Jeanie Bourke - RE: 31 Pleasant Hill (901 Washington) BP#2014-01693

Subject: Commercial Interior Renovation, 901 washington avenue, Spurwink Services

**FP-1**

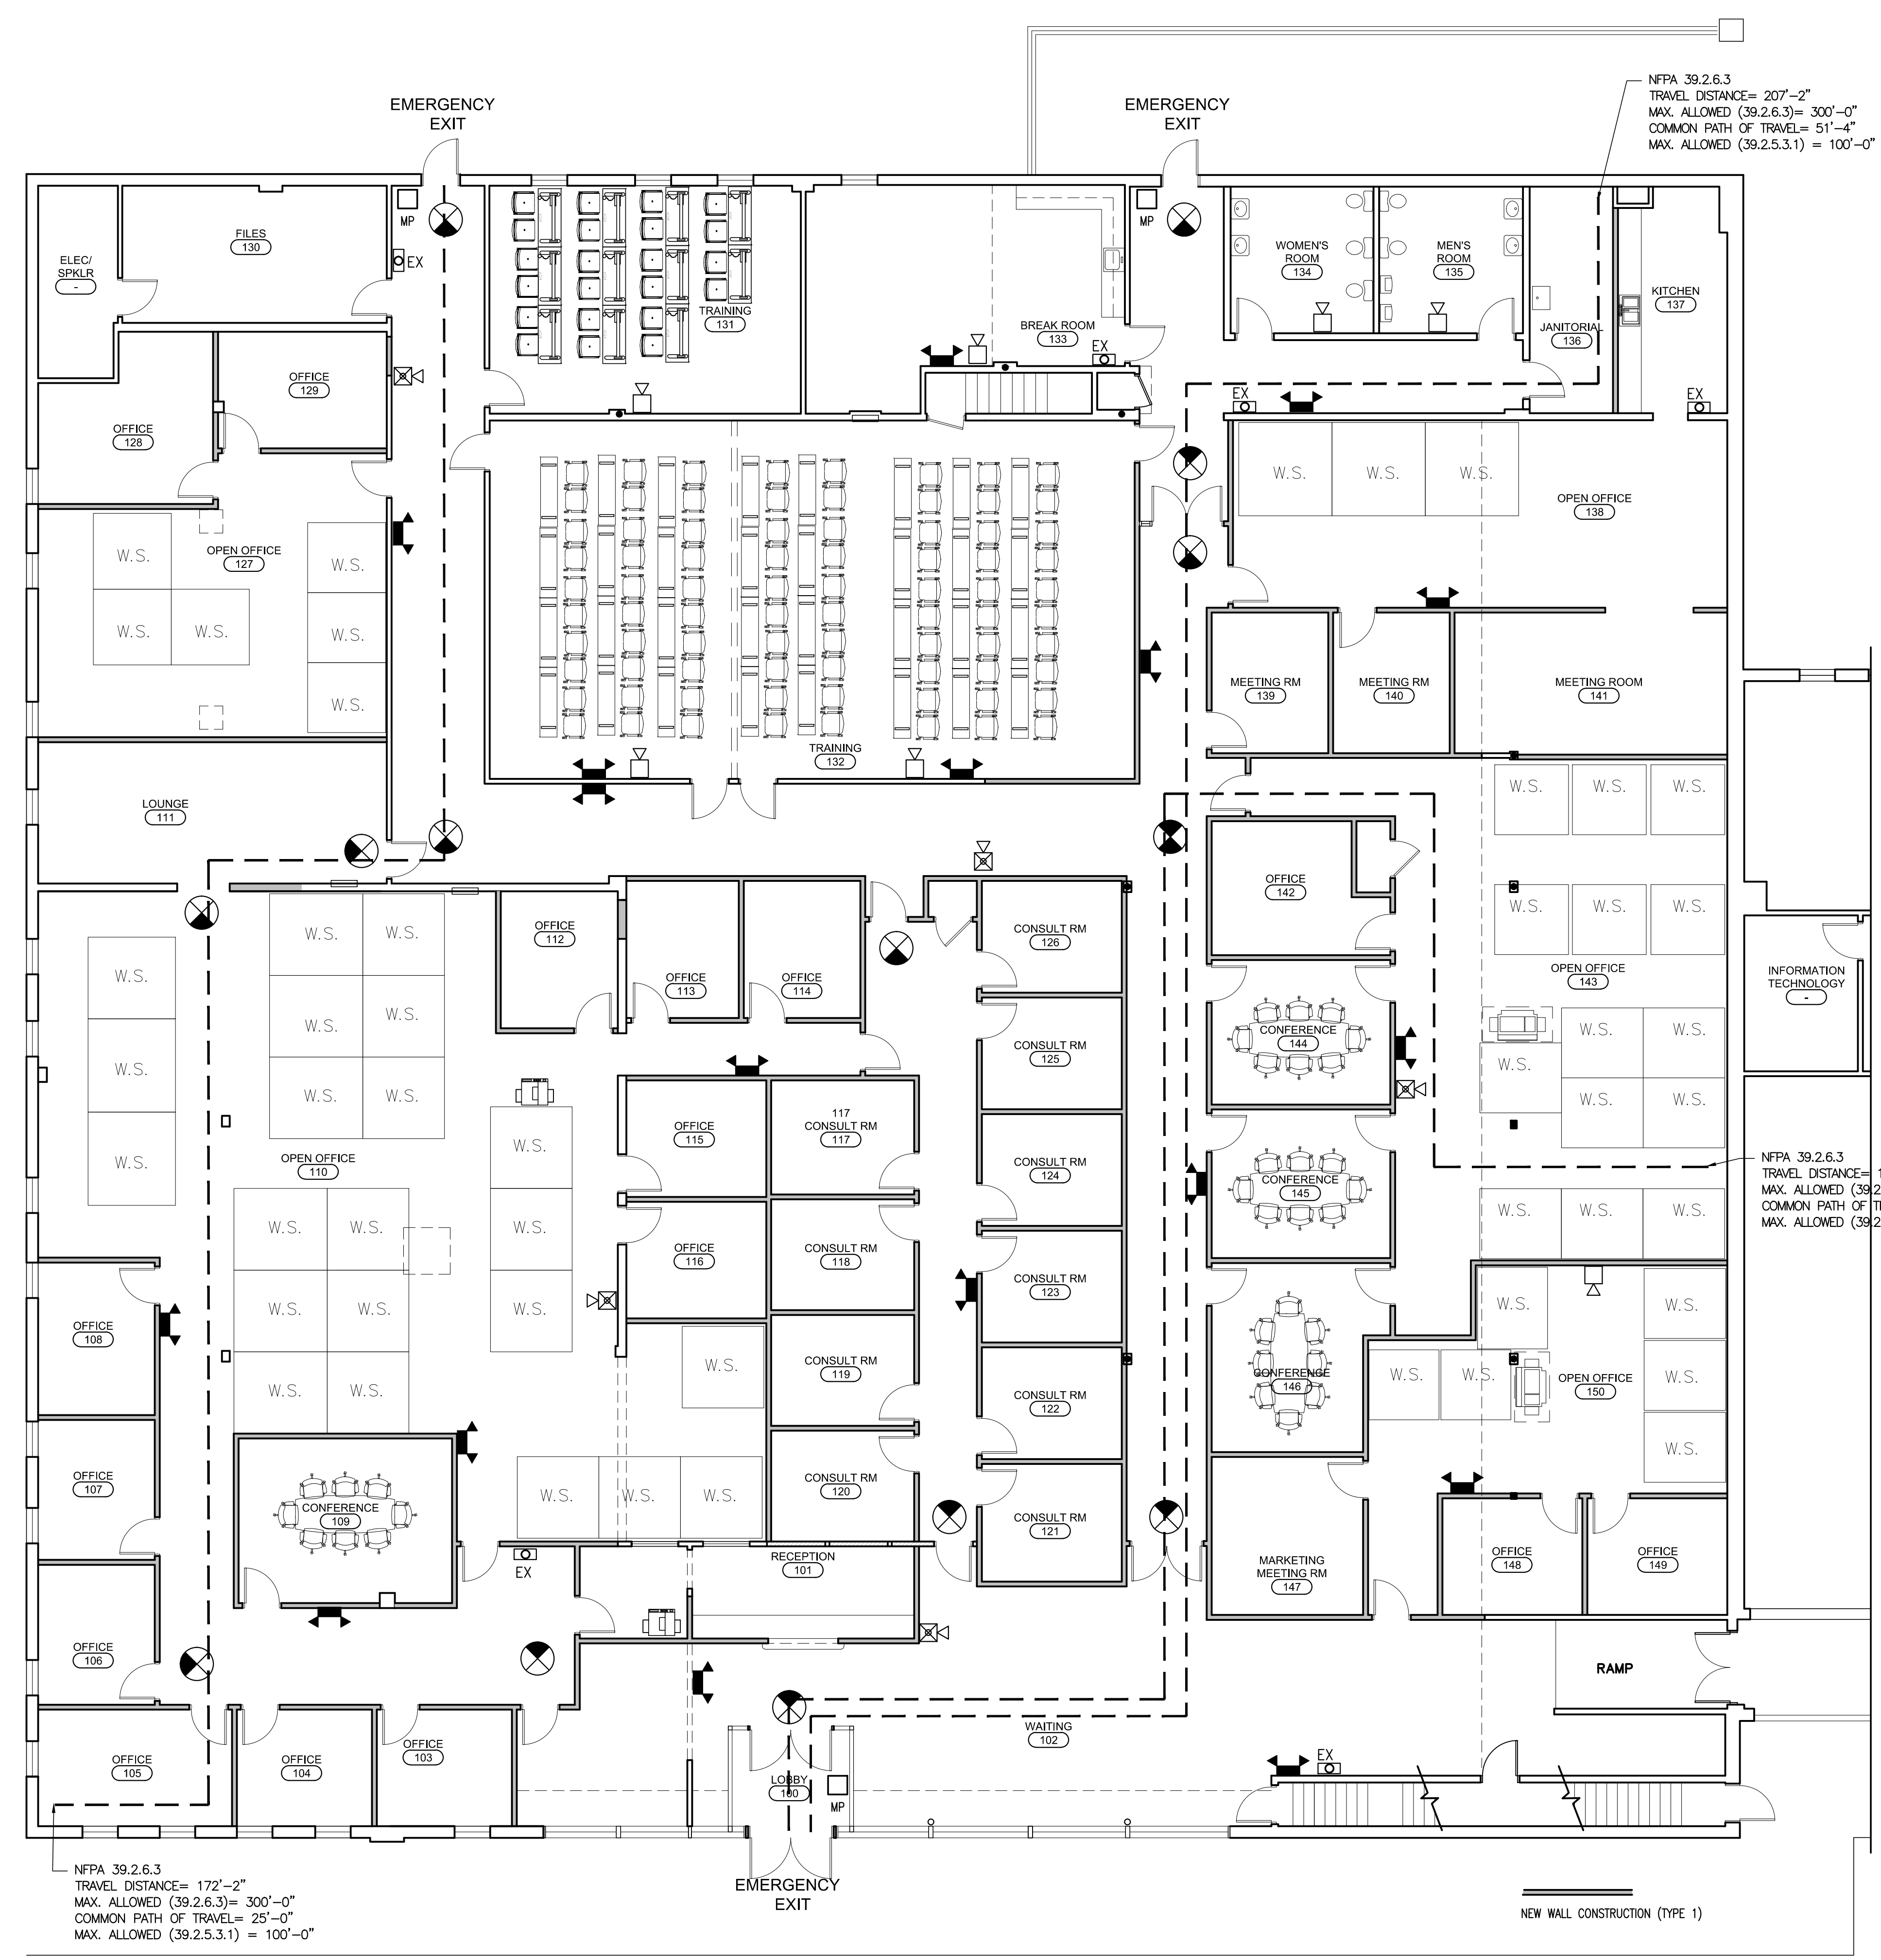
While I have your ear, I spoke with Craig today and he brought to my attention the training room capacity (80+). This room classification is now Assembly. Can you please address this in your IBC code analysis for mixed use, Sec. 508. It looks like this may qualify for the 10% Accessory allowance, however this will be for the aggregate of all assembly uses in any future expansions.

Jeanie, I spoke with Craig last week about the assembly use and separation. He understands that IBC provides an accessory allowance. NFPA 101 sec. 6.1.14.1.3 provides some exceptions for incidental occupancy.

I explained that the existing room is not separated and the occupancy calculation of the existing room is calculated at 86. The renovation is increasing the occupancy of the room by 27. This space is intended to be used by the Spurwink employees for training. Spurwink has indicated that they have a monthly training meeting and the likely occupancy will be approximately 50 employees.

I have updated my drawing FP-1 and added the IBC 508.2, on the Accessory Allowance. The drawing is attached for your review. Do you want me to upload this through the normal channels? Should I cloud the revisions?
